Our Ref: AA:KC:37842

7<sup>th</sup> October 2009

**RE: NEWCASTLE PRIVATE HOSPITAL – PROJECT APPLICATION (MP08\_0170)  
RESPONSE TO SUBMISSIONS**

Drawing CARPARK ALTERATIONS			
Date	28/09/2009	Drawn	NB
File Name	E:\10000\10000\10041\0-Base\10041_DA_Host_2.pln	Project Number	10041
Drawing Number	SK114	Issue	A

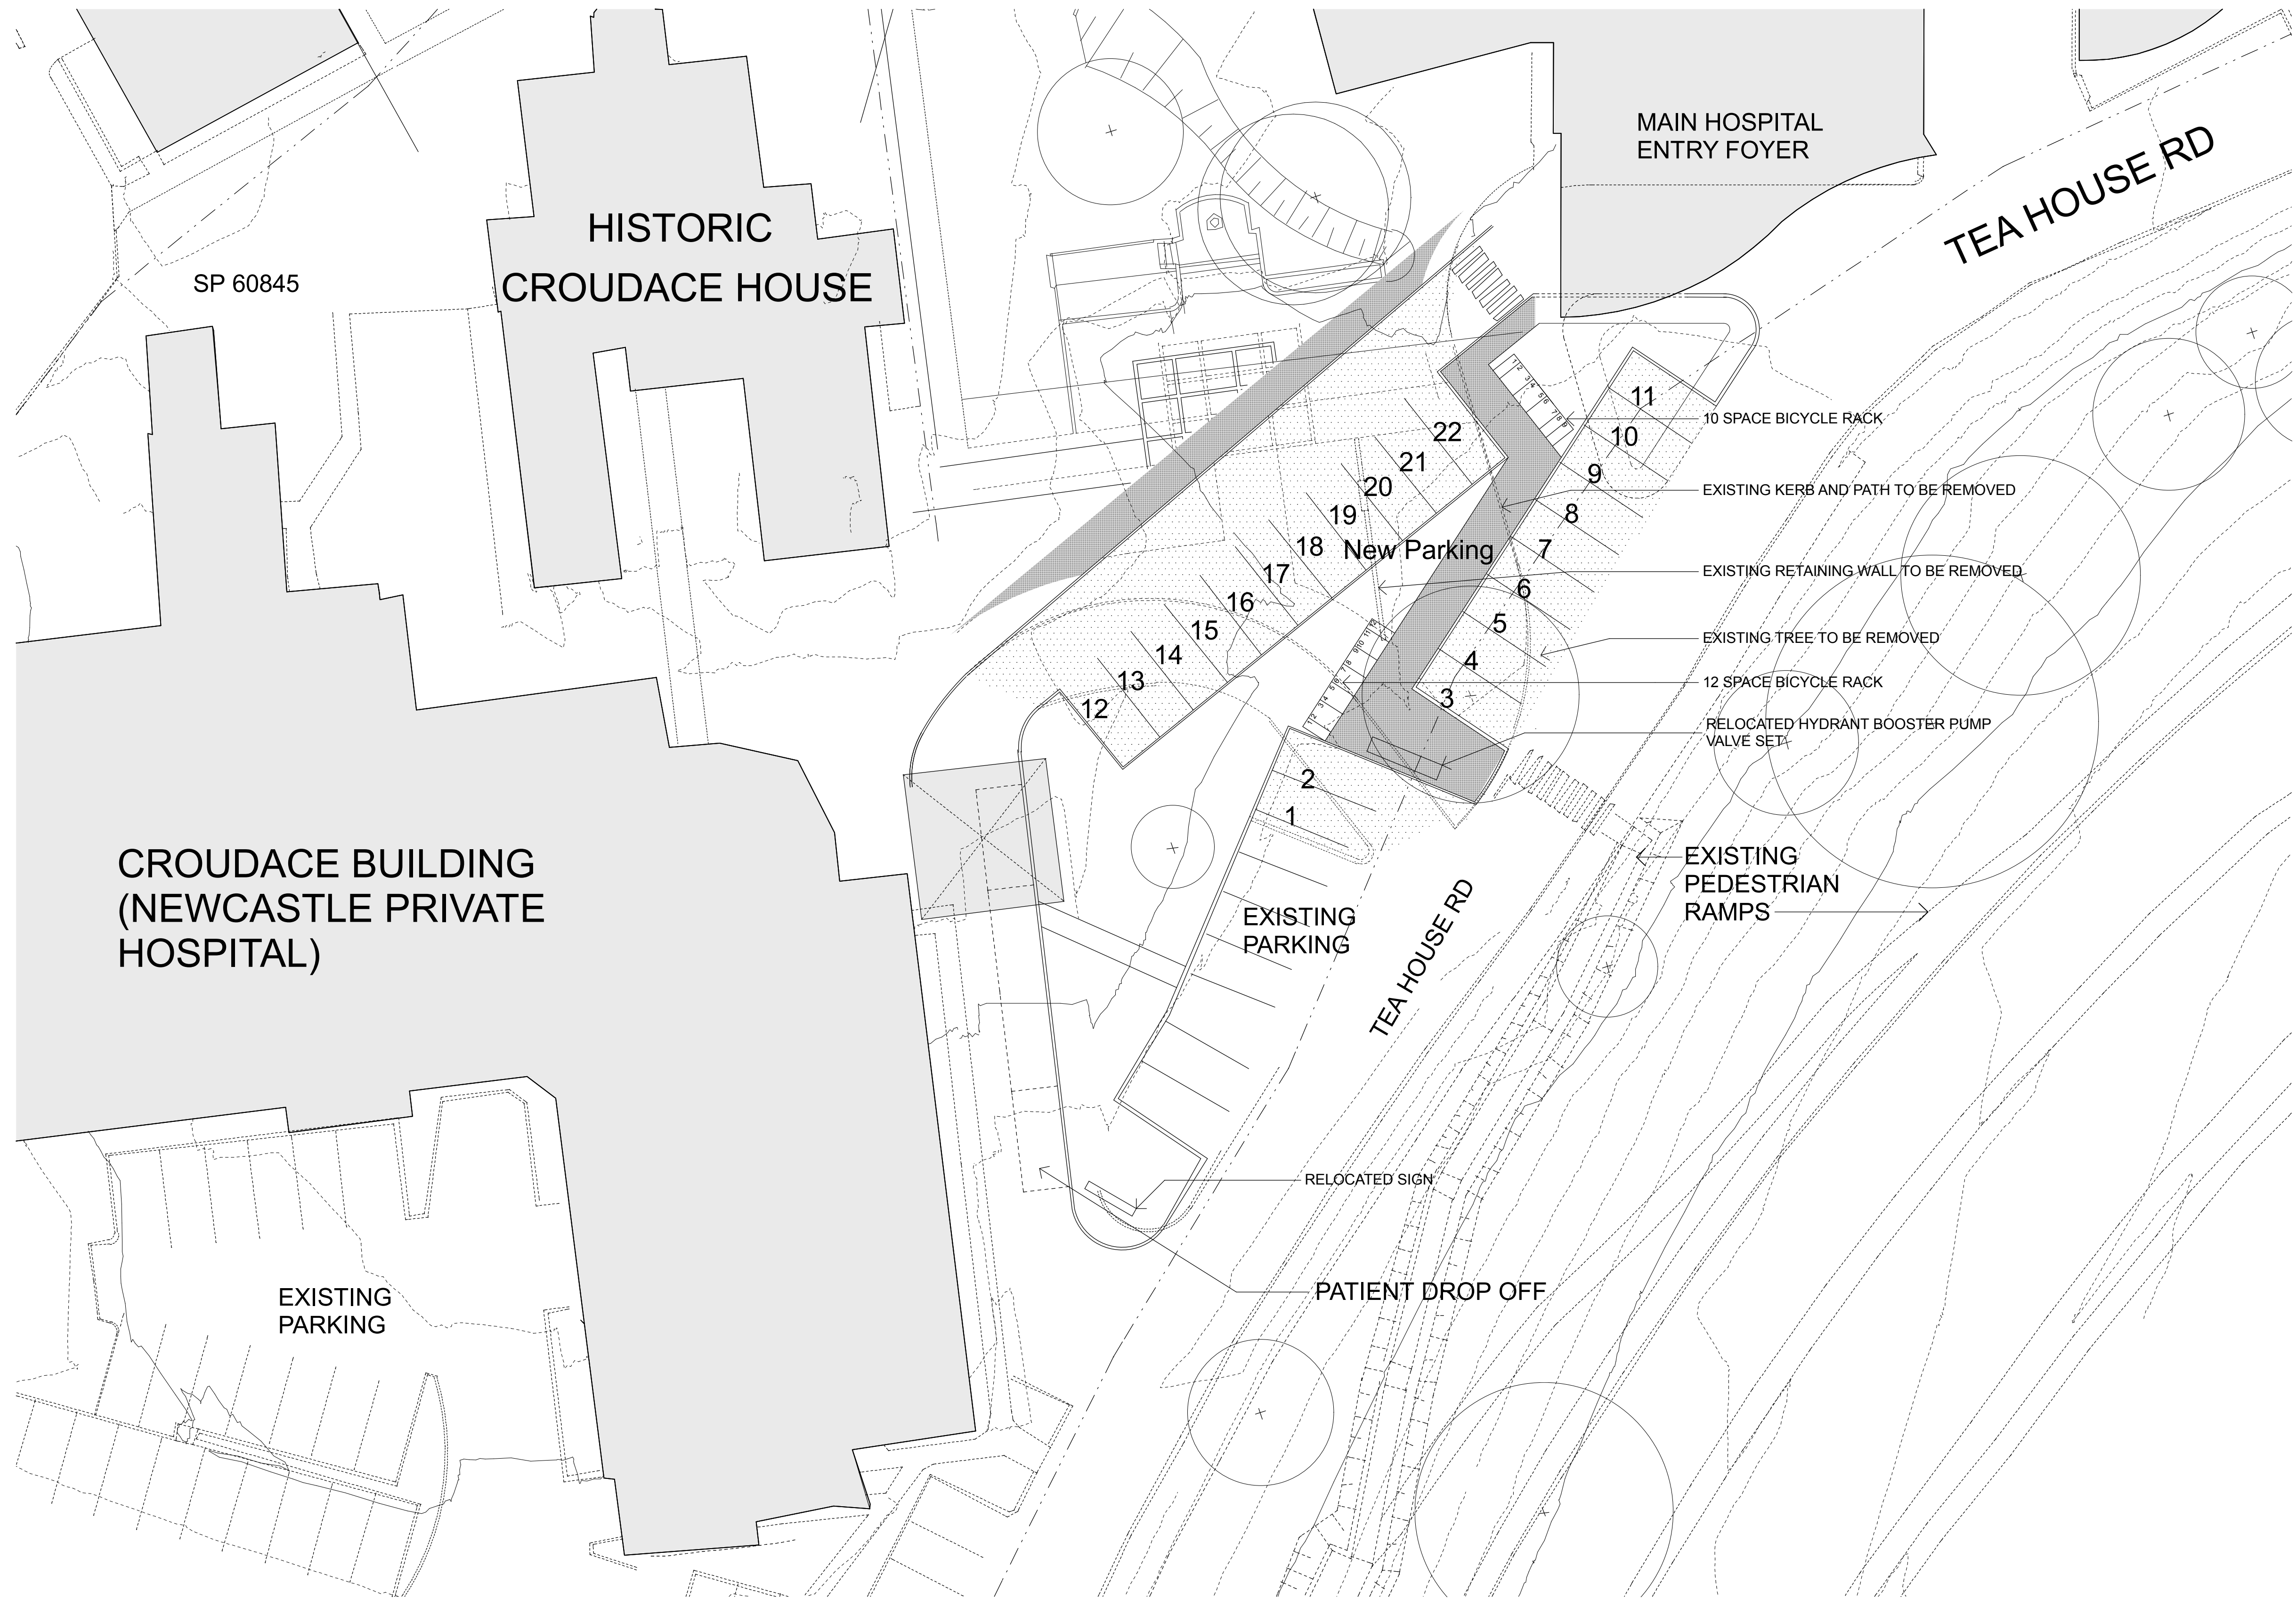
- Provision of 22 public bicycle parks near the at-grade car park area at the front of the existing Kingston and Croudace Buildings (refer to Suters architectural plan **SK114** at **Appendix C**) and 19 secure bicycle parks provided in storage area within the existing Kingston Building (refer to Suters architectural plan **SK104** at **Appendix C**), which is in excess of that required in Table 1b of Part 4 of Newcastle City Council's DCP 2005.

Please refer to Suters architectural plan **SK114** (at **Appendix C**) which provides greater detail of the proposed at grade car parking at the front of the existing Kingston and Croudace Buildings.

Drawing
LEVEL B3
 Scale Date Drawn
1:200 @ B1 25/09/2009 NB
 File Name
 E:\110000\110000\10041\0-Base\10041_DA_Host_2.pln
 Project Number Drawing Number Issue
10041 SK102 Q

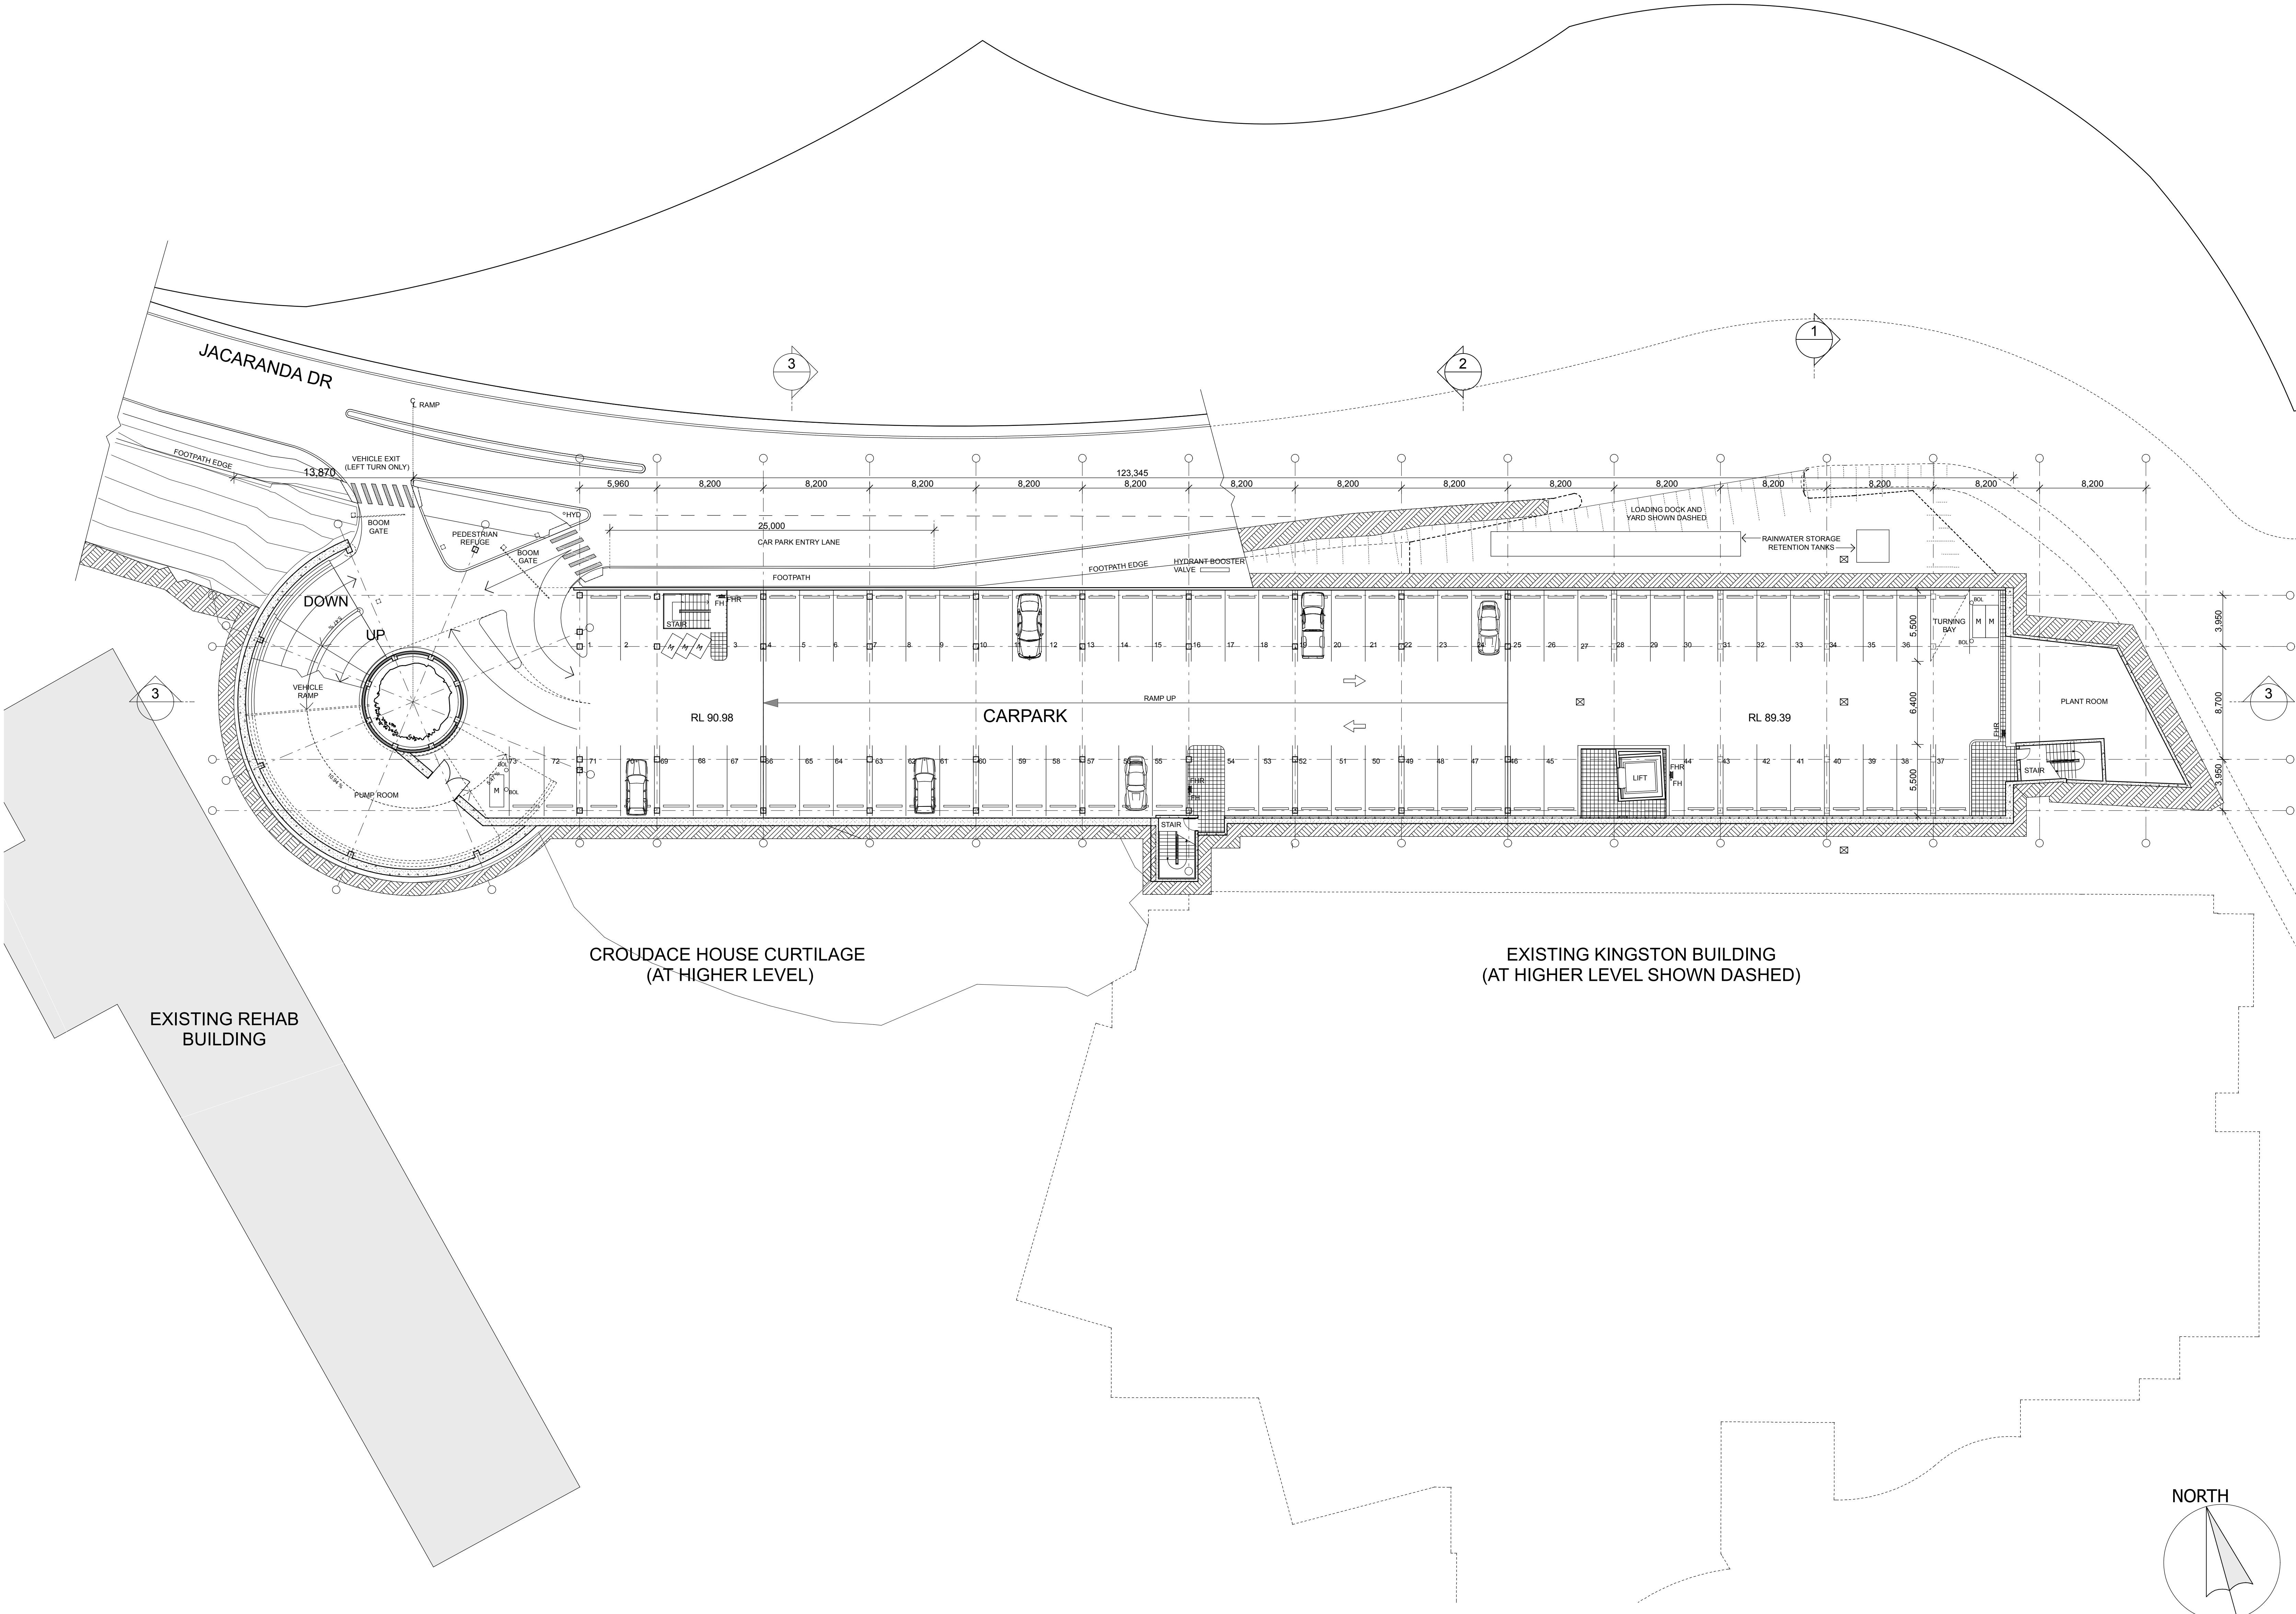
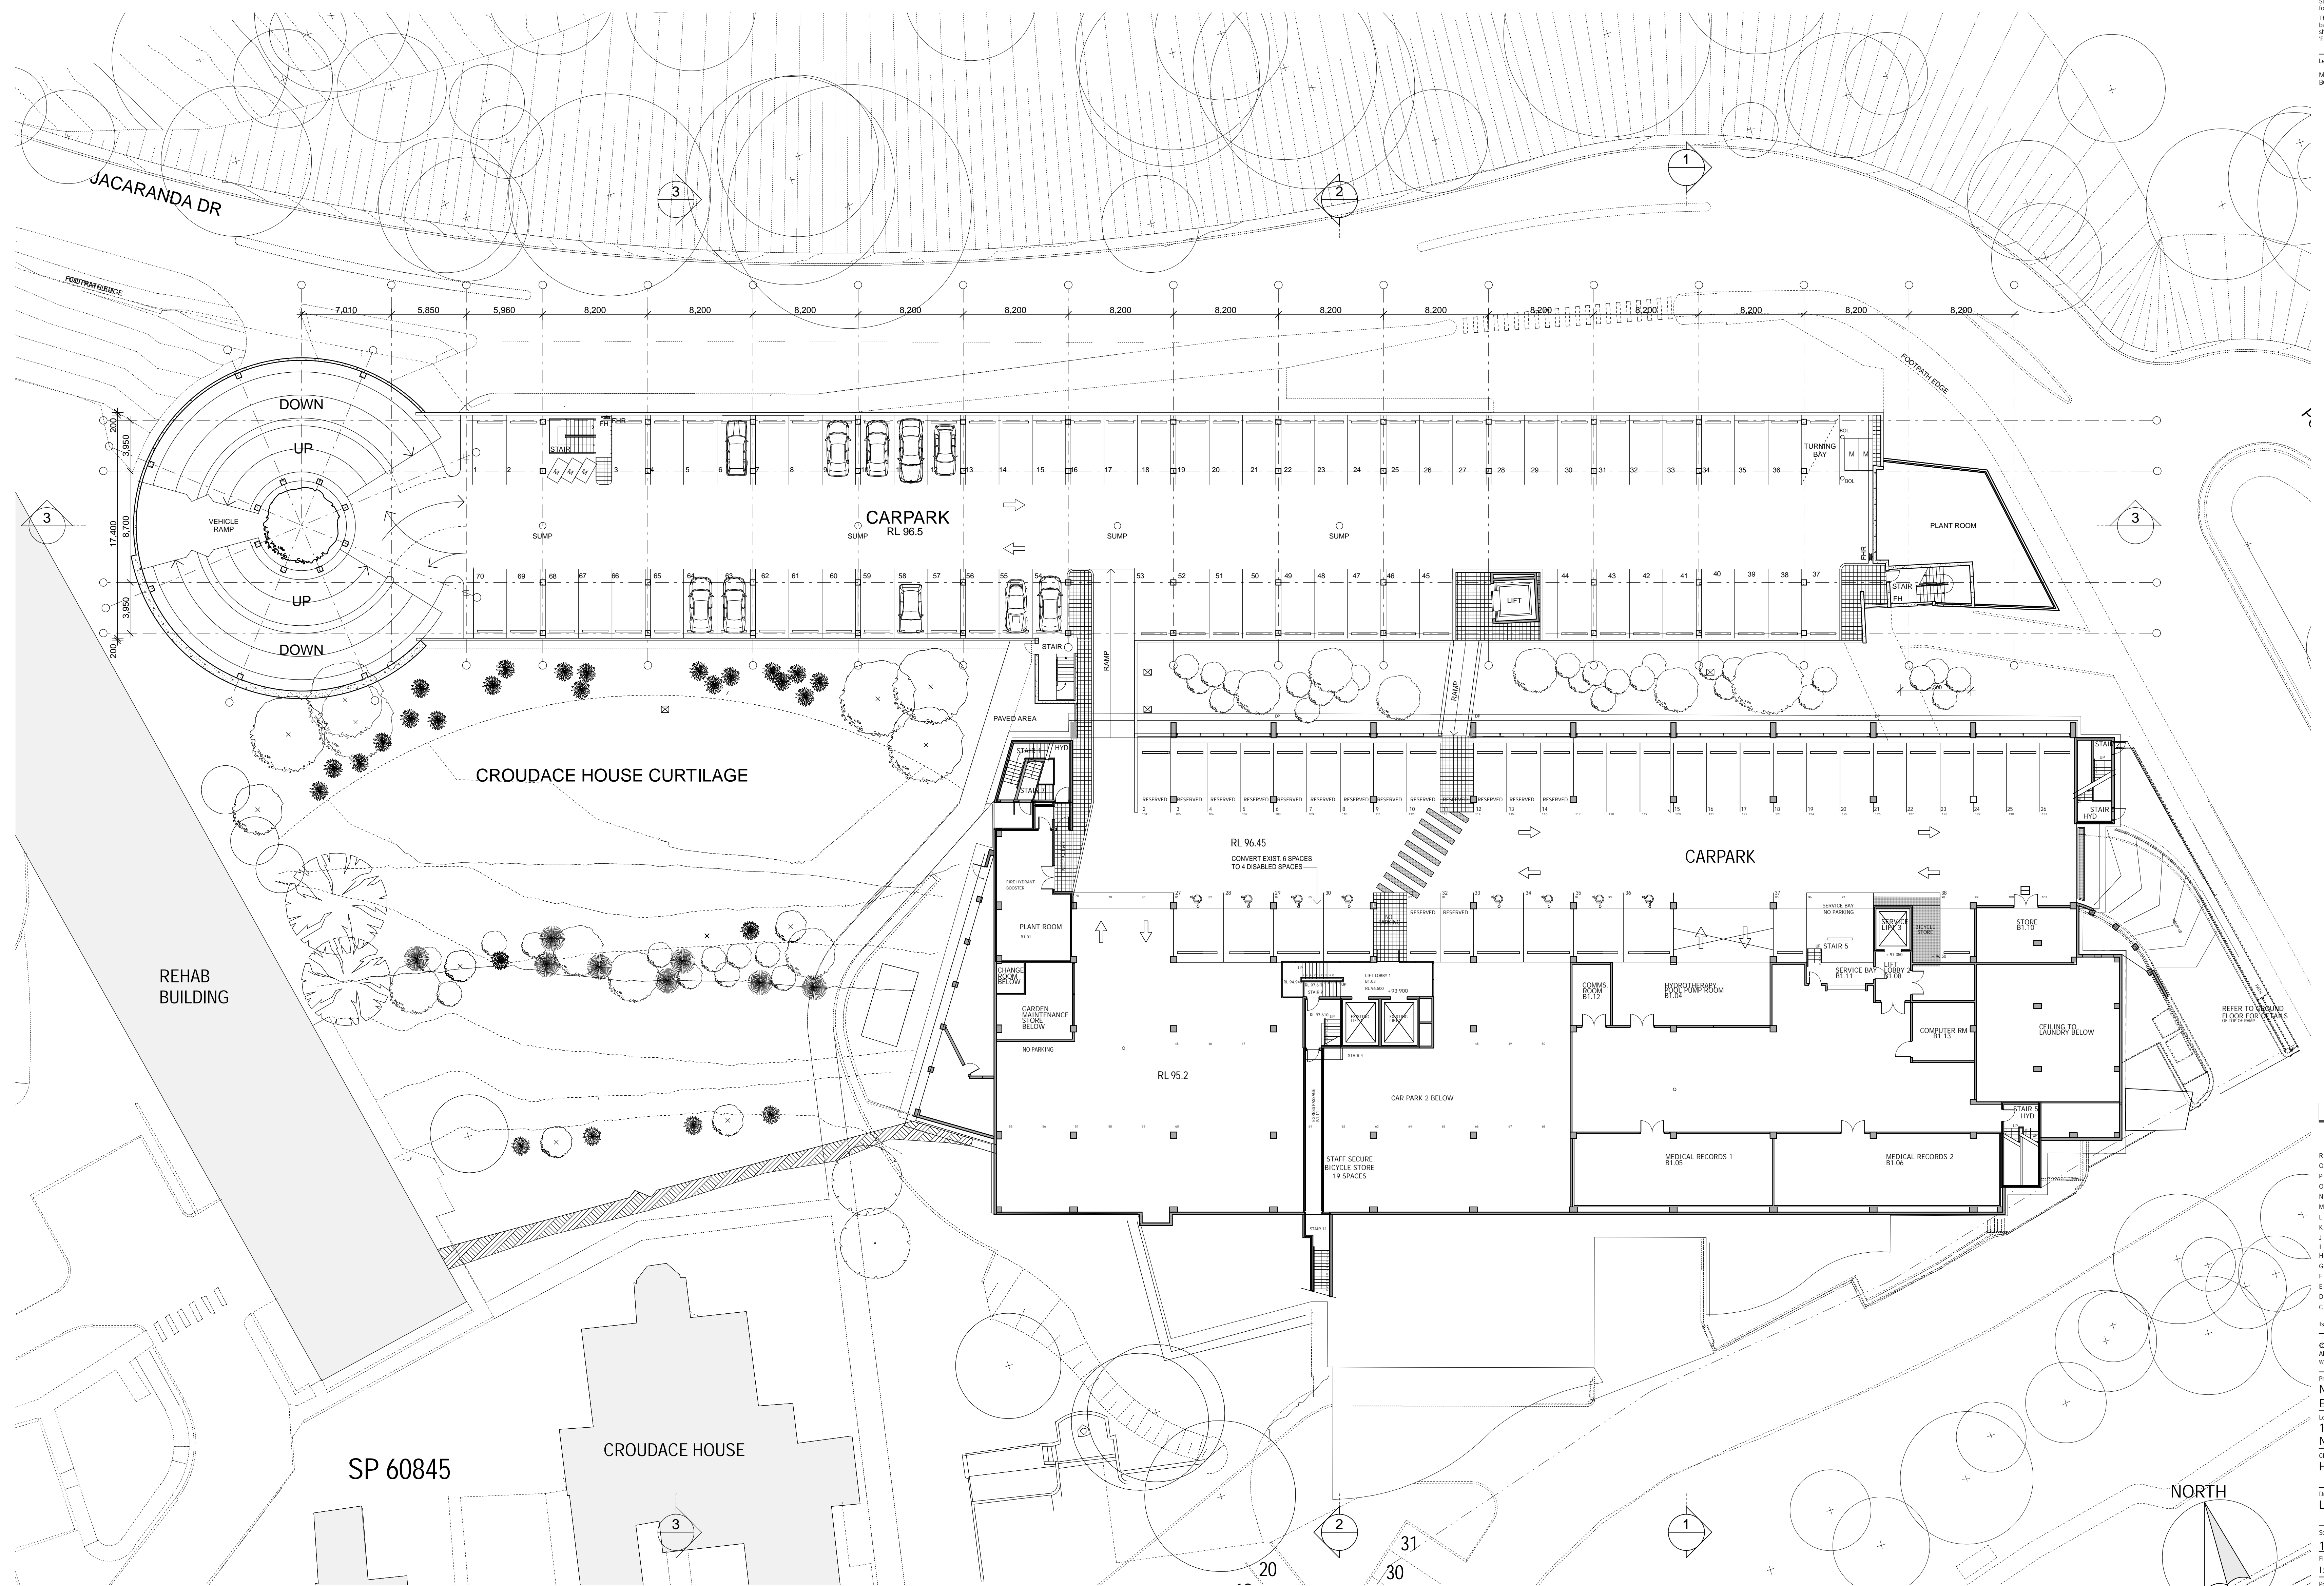
- Allocation of 25 motorcycle parking bays within the existing and proposed multi-level car parks (refer to Suters architectural plans **SK102 – SK105** attached at **Appendix C**), to comply with Table 1b of Part 4 of Newcastle City Council's DCP 2005.
